Please ask for: Nicola Moore
Email: nicola.moore@arun.gov.uk
Telephone: Ext 37944
Our Ref: LU/153/20/HH
Your Ref:
Date: 24th June 2020

Application for Planning Permission for Works or Extension to a Dwelling

Development: Front porch
Location: 30 Lansdowne Road Littlehampton BN17 6JG

Site Plan at 1:500 Scale

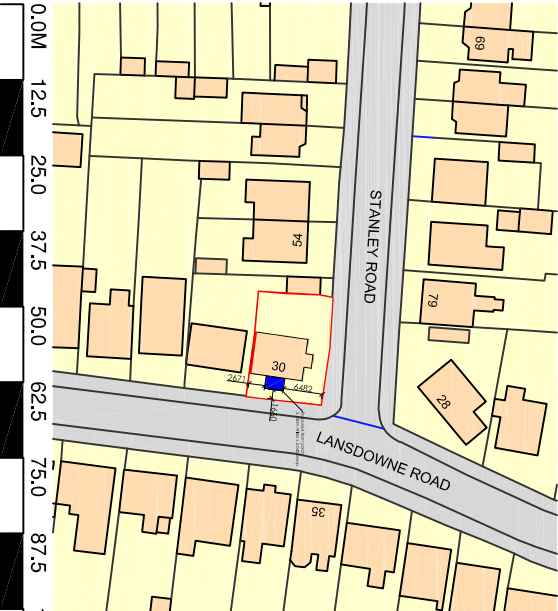
The scale bar on the site plan appears to be incorrect. On measuring it is at a scale of 1:1250 and not 1:500. Please amend accordingly and re submit.
